**Consultation Response from Alan Smith,  
KC Waste Strategy (Refuse & Recycling)**

**2025/91781 Bradley Villa Farm, Bradley Road, Bradley, Huddersfield, HD2 2JY**

**Date Responded: 21/07/2025**

**Responding Ref: WPS 25 022**

Rev.	Date	Author	Info
A	1 Nov 2023	Electric signpost with two signs	1:200
B	7 Feb 2024	Update to electrical signpost comments	1:200
C	6 July 2024	Update to site entrance arrangement	1:200
D	1 Jan 2025	Final design for review & for site preparation reference drawings	1:200

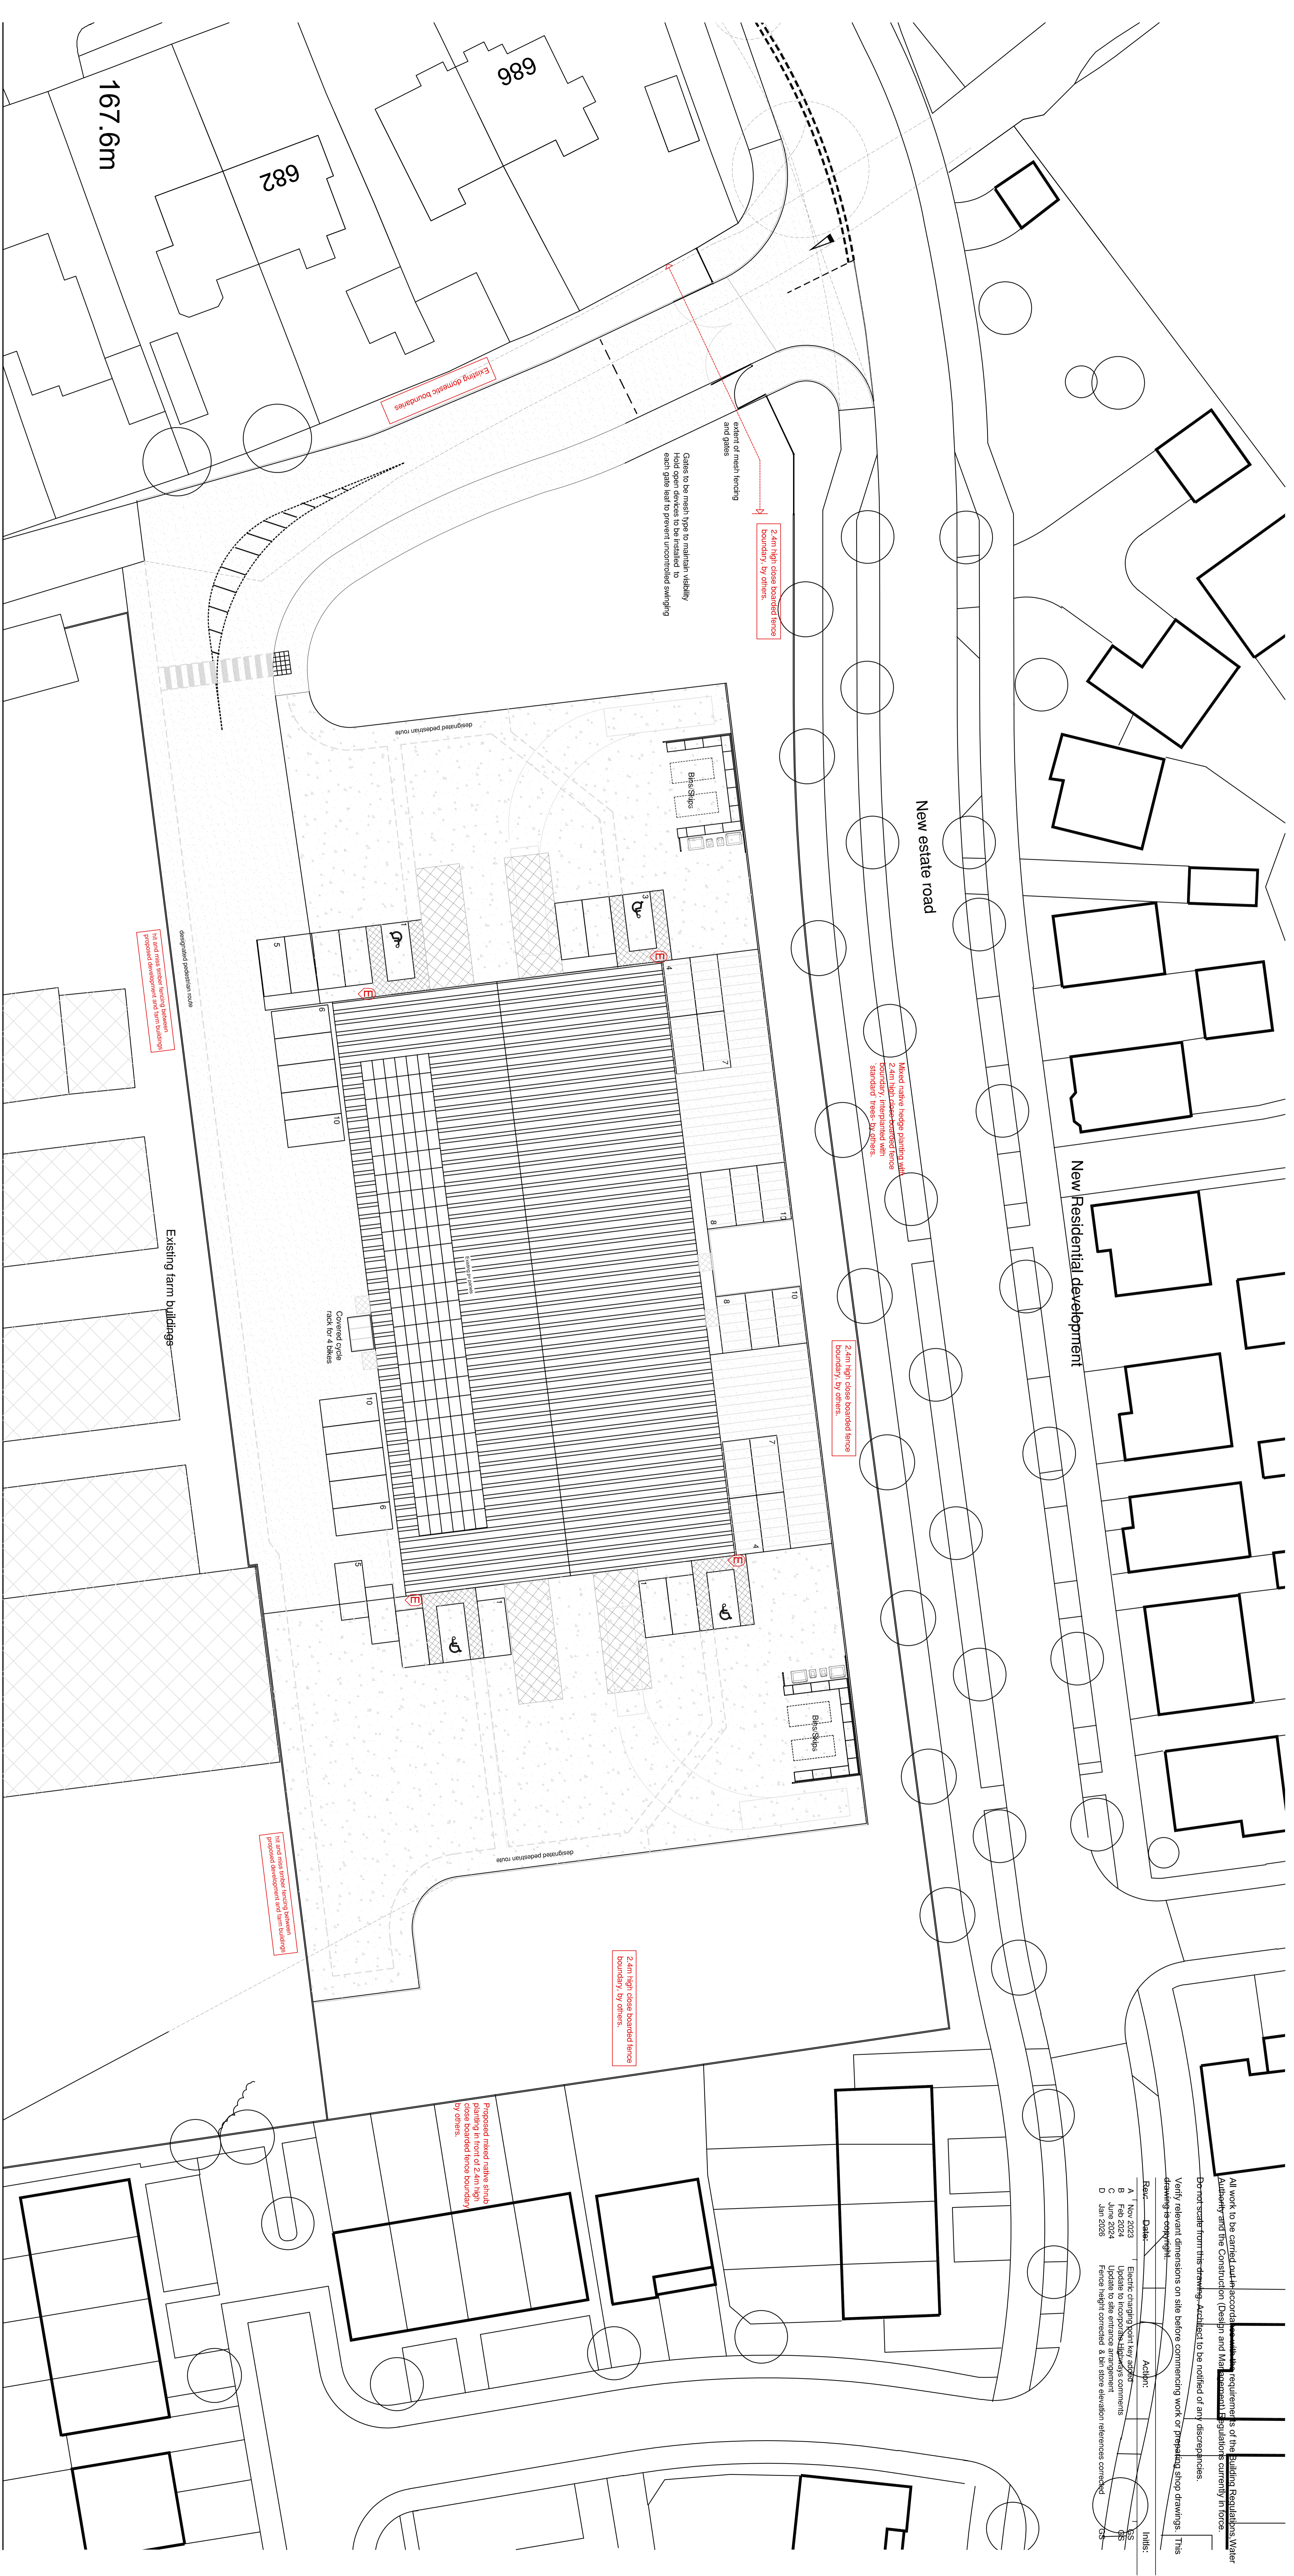
Waste management details for the site are contained in the document, “General [id 1093852] Size: 1.3MB 30/06/2025 - 1362-01-SK-10 - Site layout - Boundaries-Finishes-Bin stores-Car charger”. This document shows the proposed bin store, shown below.

The proposed bin store is of a size that will contain a wide range of suitable waste and recycling containers.

- There are two bin compounds shown on the plan in the northwest and northeast corners, these are more than 6m away from the building. If not using skips or FELs, the drag out distance for wheeled bins from a bin store / premises to the collection vehicle should preferably be under 15m. Access to and from the bin storage area should be constructed to withstand point loading and movement, impacts of larger bins over time, and to resist future rutting, pitting, cracking or other such surface degradation that

would impair bin manoeuvring. From the plan this looks like the bin store will be readily accessible with minimal drag out distances.

The proposals are acceptable to the WCA, there are no additional comments.
